From: [REDACTED]
Sent: 02 December 2025 09:03
To: Planning
Subject: Planning Application 3/2025/0887

Dear Ms Walker
Re: Planning Application 3/2025/0887
Construction of a garage in the front garden of 53 Knowsley Rd Wilpshire

drawing title	Proposed Plans
dwg purpose	
scale	1:100
@ sheet size A1	rev date 11/11/25
job number	V4-GA-001
drawing number	P-1
revision

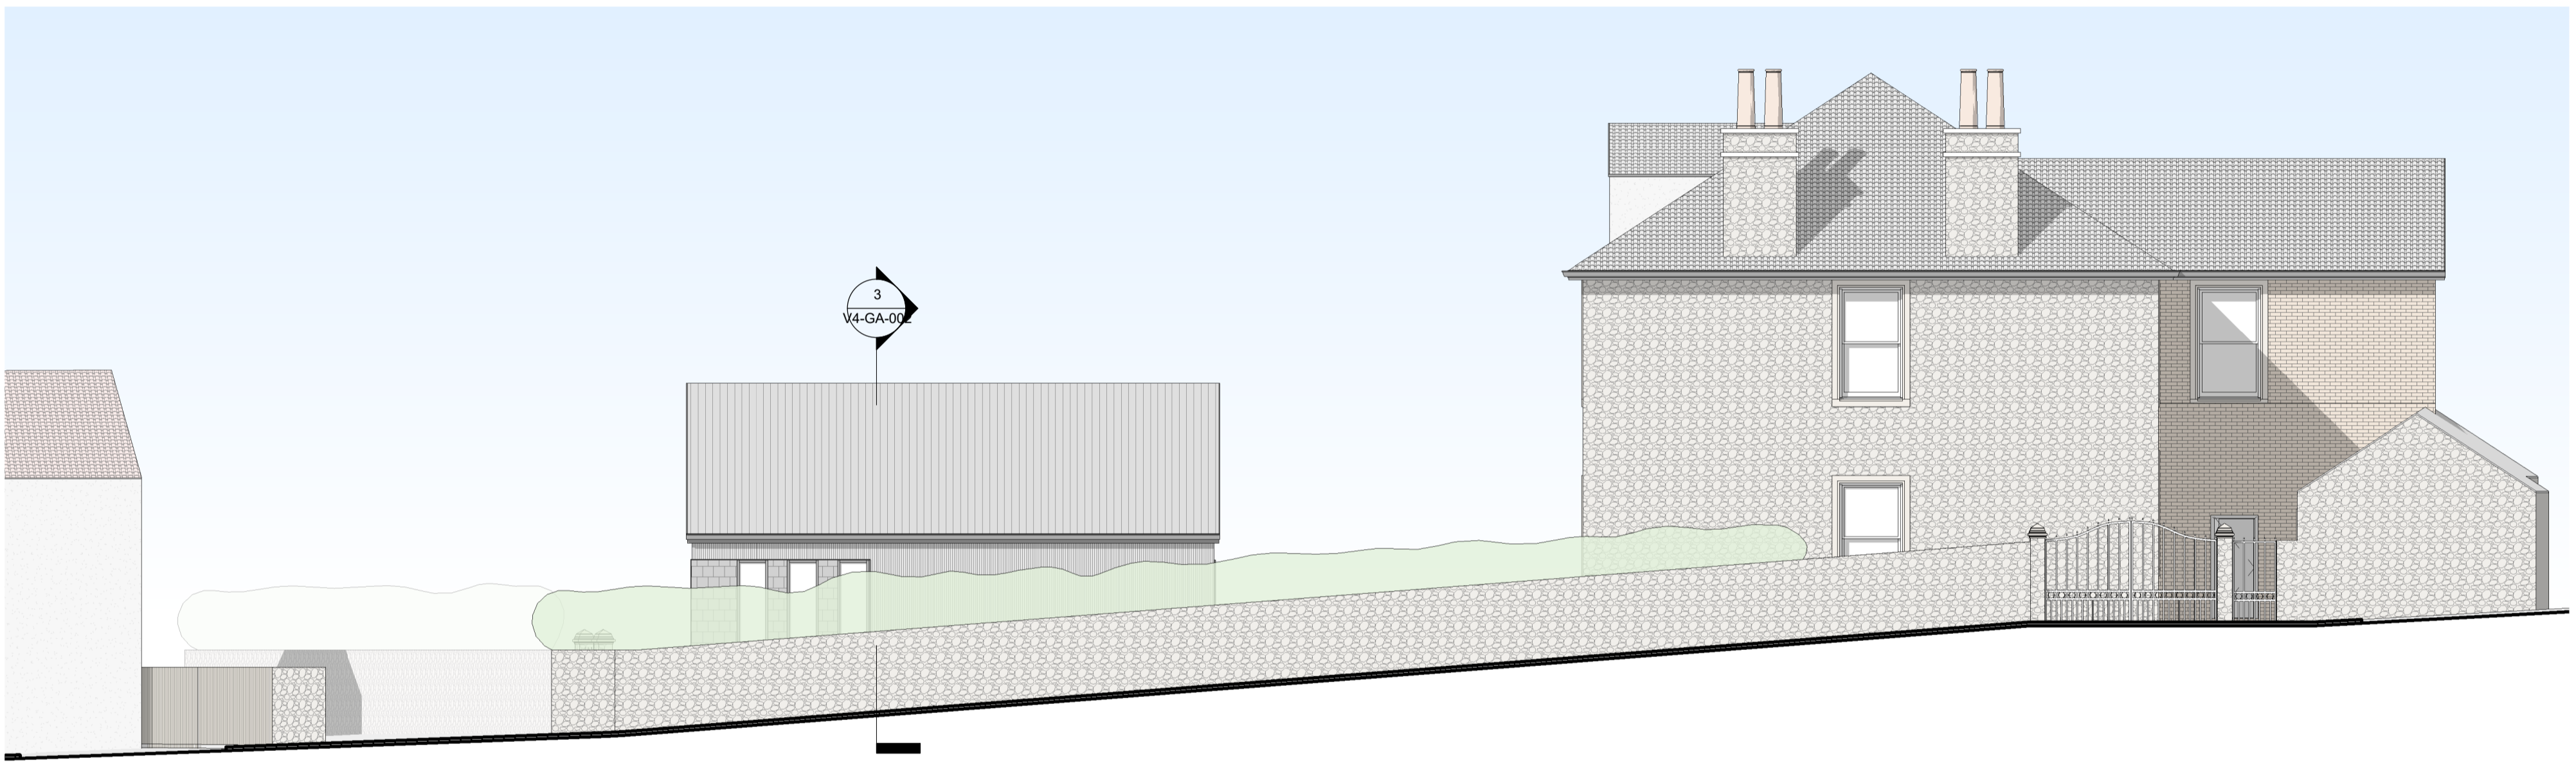
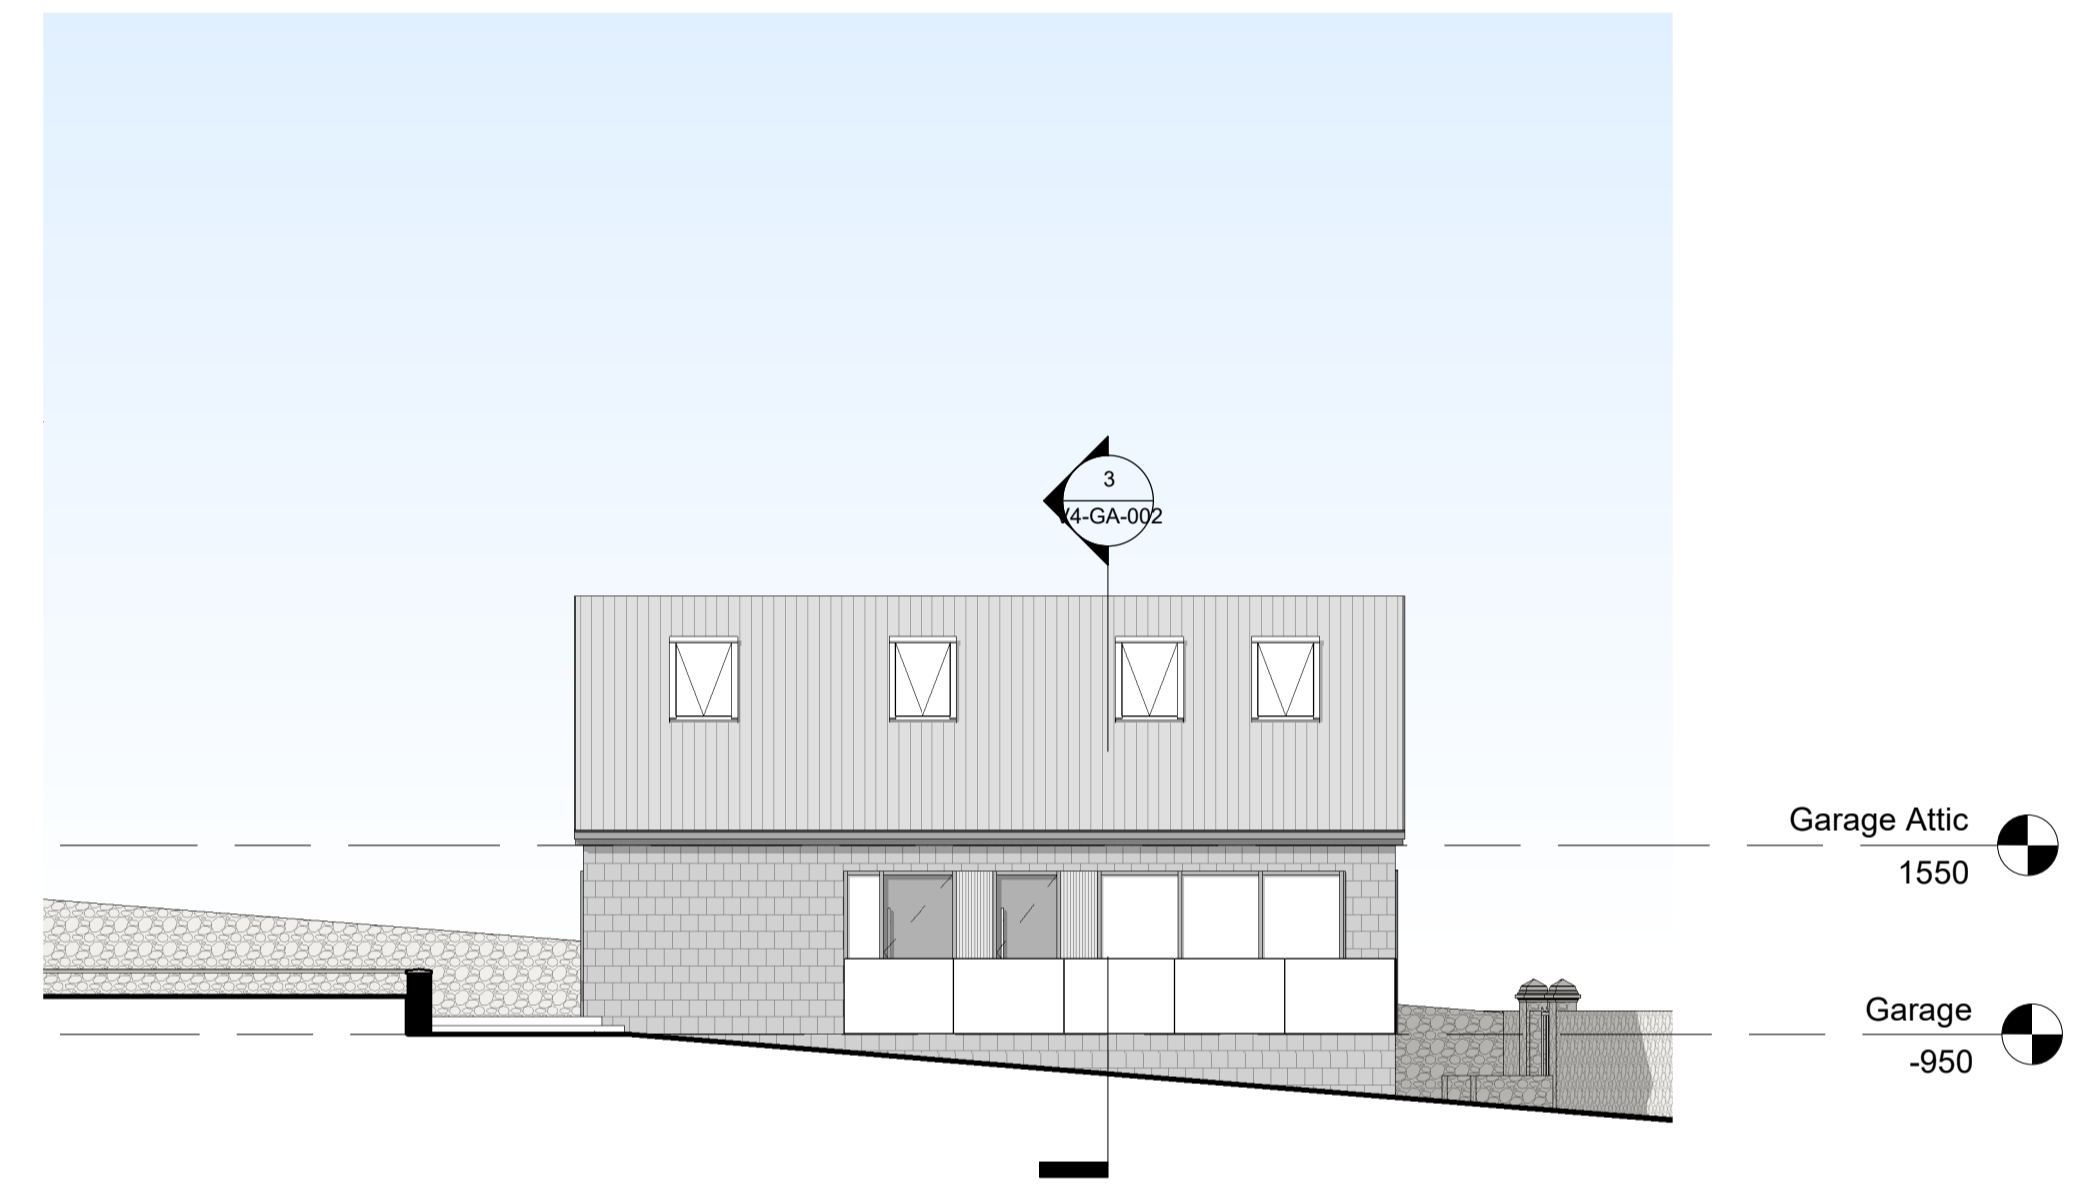
The proposed building will [REDACTED]. The three gym windows and high pitched roof will be in [REDACTED] and be totally overpowering. It is positioned extremely close to the roadside and will not be hidden by the Yew hedge, making it even more intrusive. The building line has been totally ignored to the detriment of the street scene. Due to the gradient of the road and the sloping site the proposed building would appear even higher and more dominant from [REDACTED]. The design of the proposed building having modern aluminium windows and cladding is totally out of character with the main house and will not be in keeping with the area. This type of cladding was refused in a recent Application for a neighbouring new build property.

In conclusion the proposed 'garage' is a two storey building with a 25 sq metre gym and a large upper floor attic. It appears to be more a residential property having patio doors, a large raised terrace and a glass balcony to the rear. The height and length of the proposed building takes away the openness and character of the area and will appear totally overbearing. The scale of the building in a front garden is far too large, 33 feet in length plus a high pitched roof is way in excess. The position so close to the roadside will have a negative impact on the street scene and is totally unacceptable.

Comments: Just concerned that the height of the garage would block a lot of natural sunlight

drawing title  
Proposed Plans  
dwg purpose  
scale As indicated  
@ sheet size A1 rev date  
job number V4-GA-002  
drawing number revision

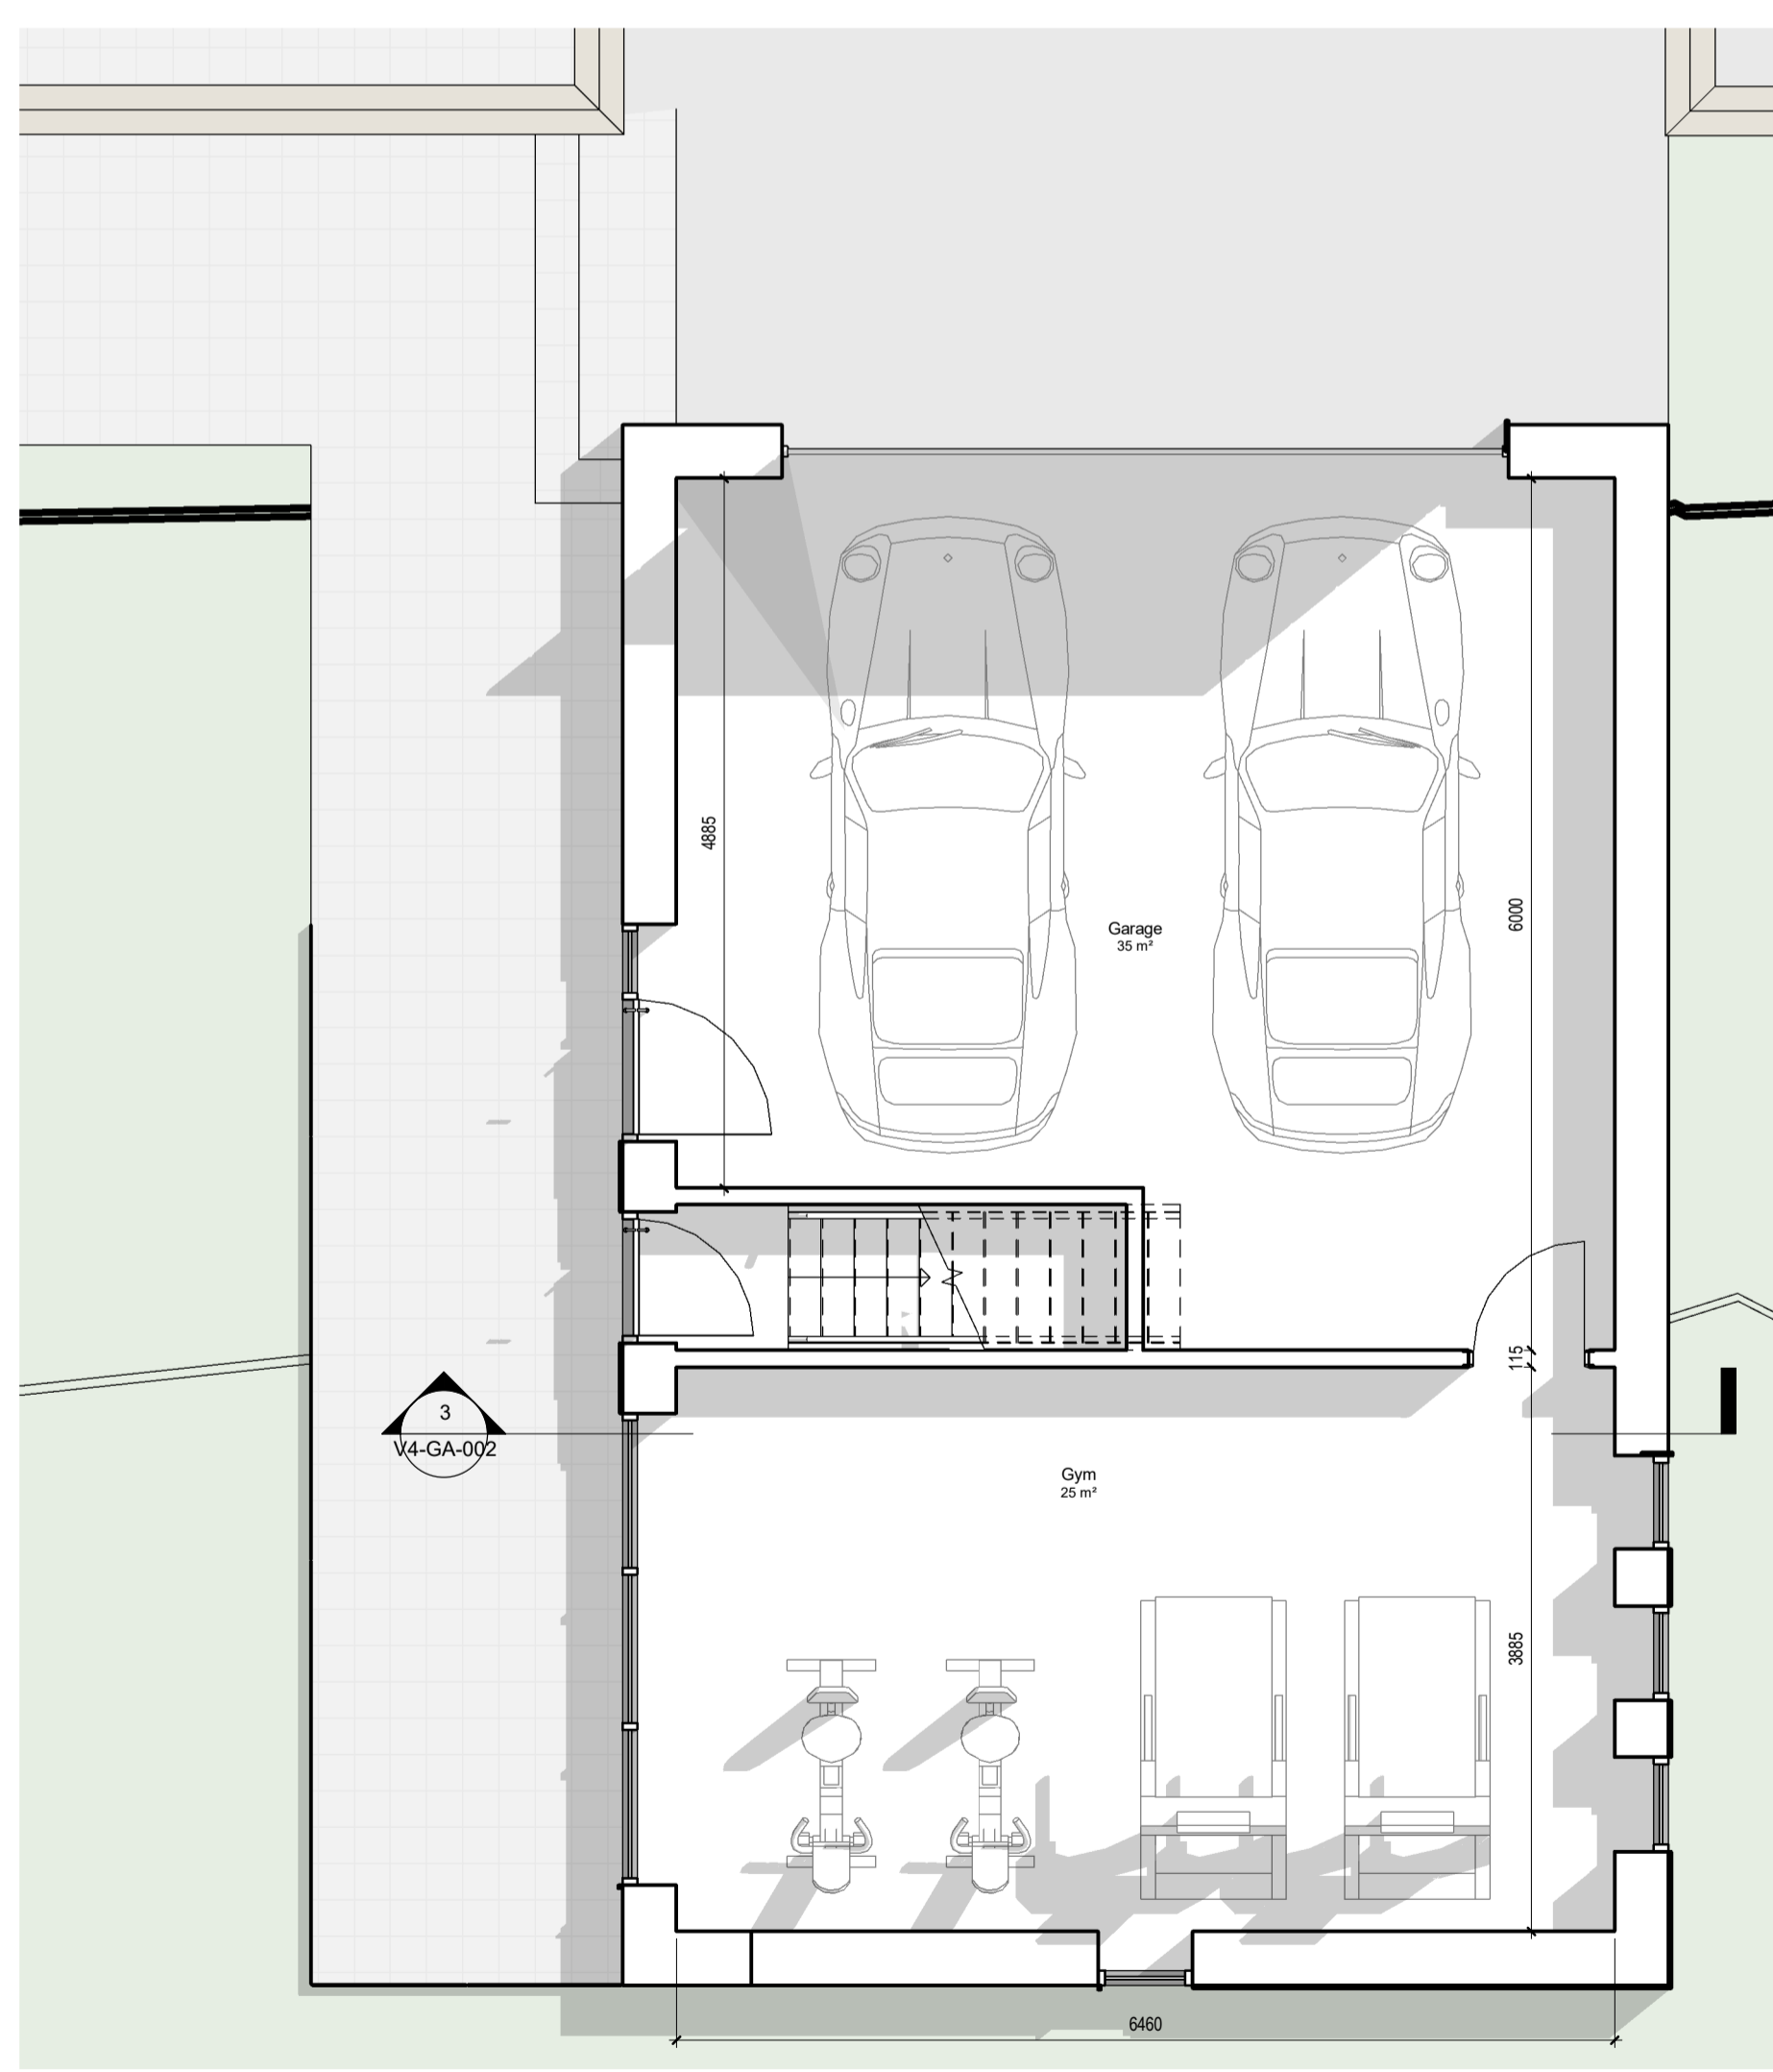
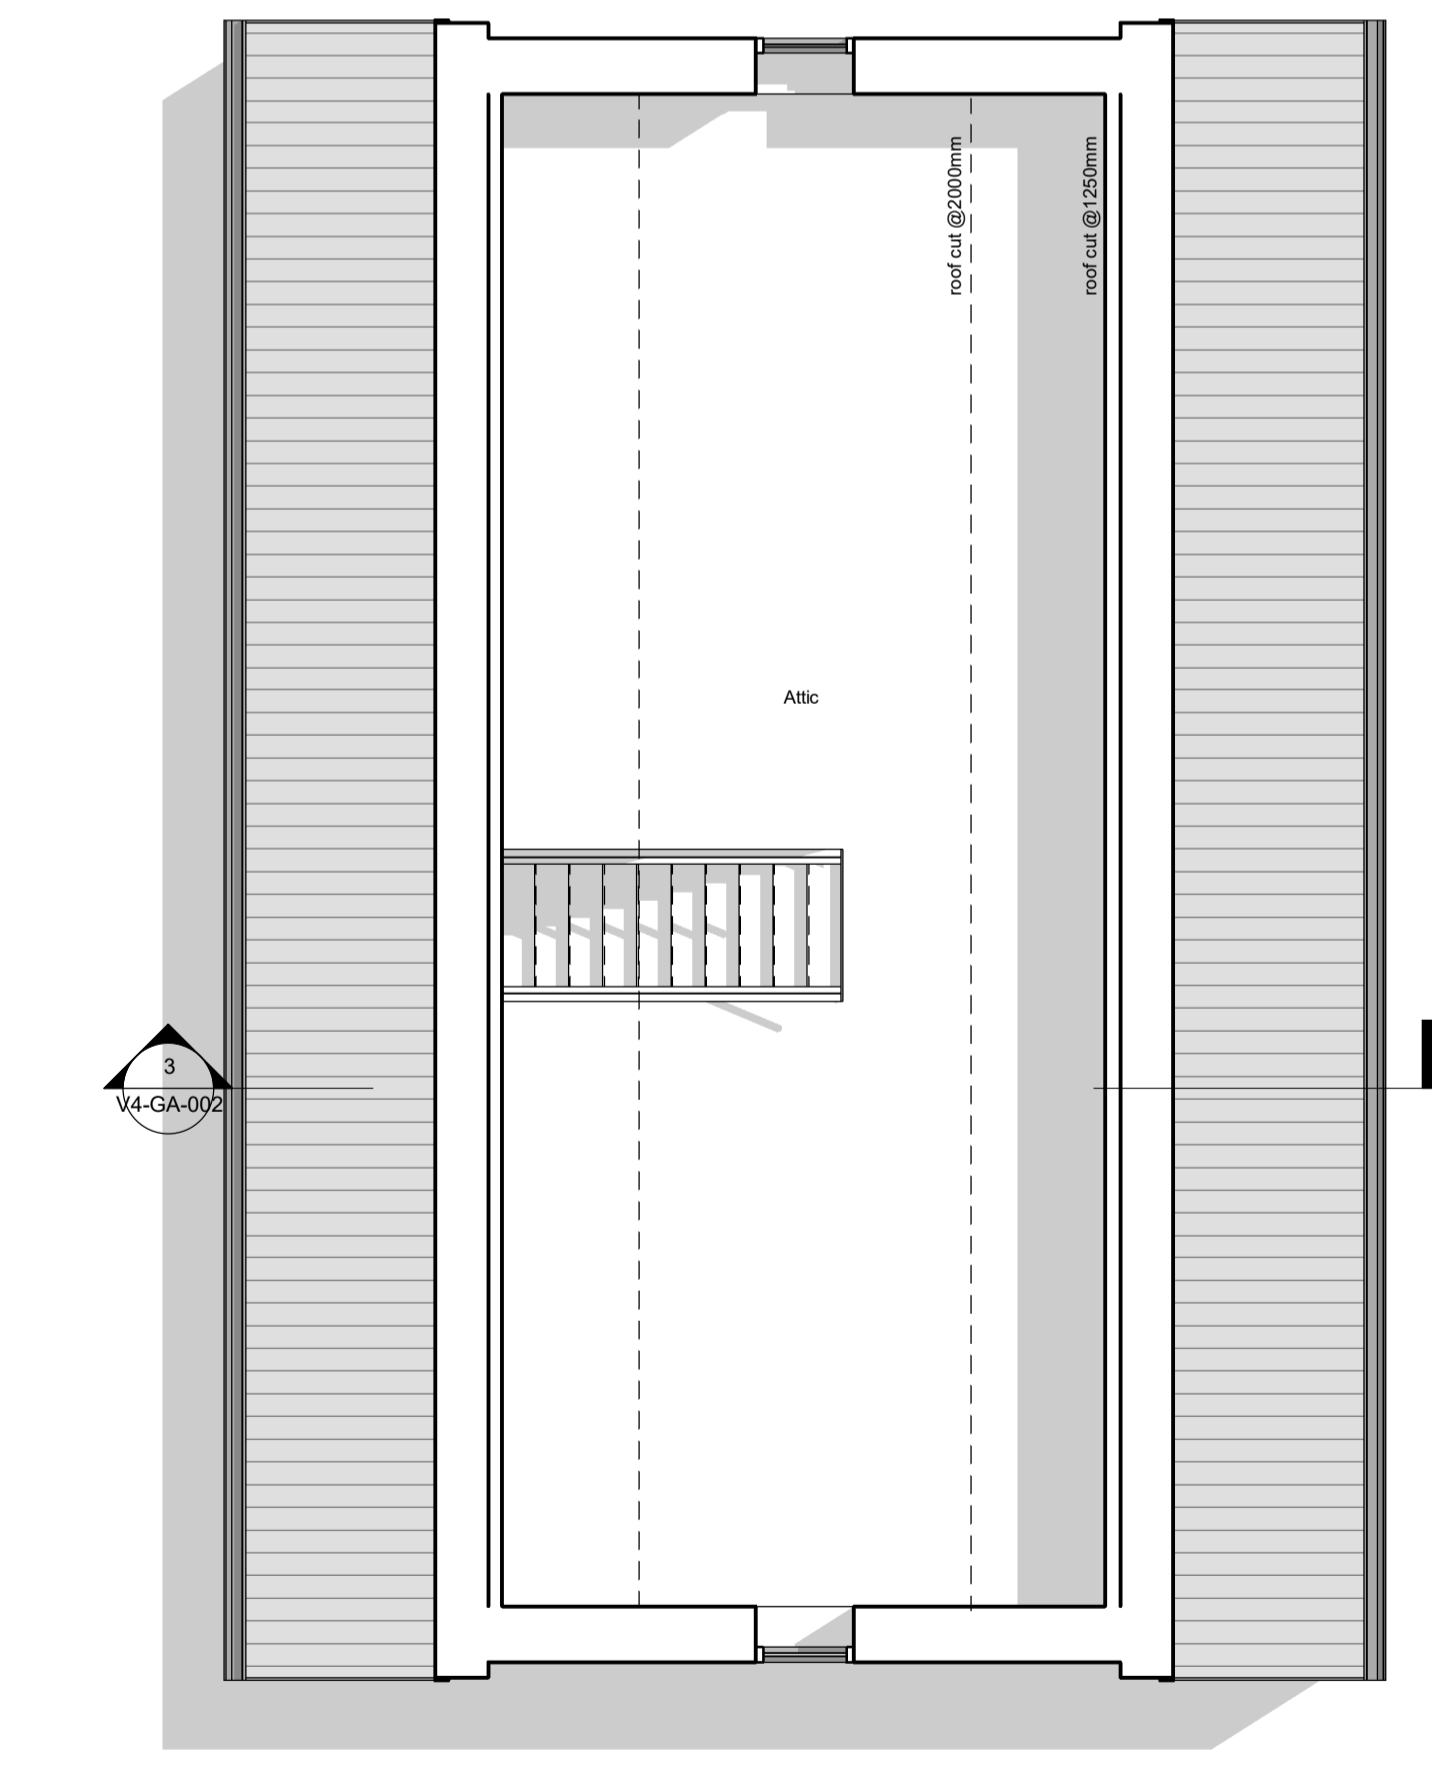
We wish to register our strong objections to the above Application. We find the Application to be very misleading as the description of the proposed work only mentions a garage. It is a two storey property in the front garden of No.53 including a double garage, a large gym, plus an upper floor attic, accessed by an internal staircase. Hardly just a garage.
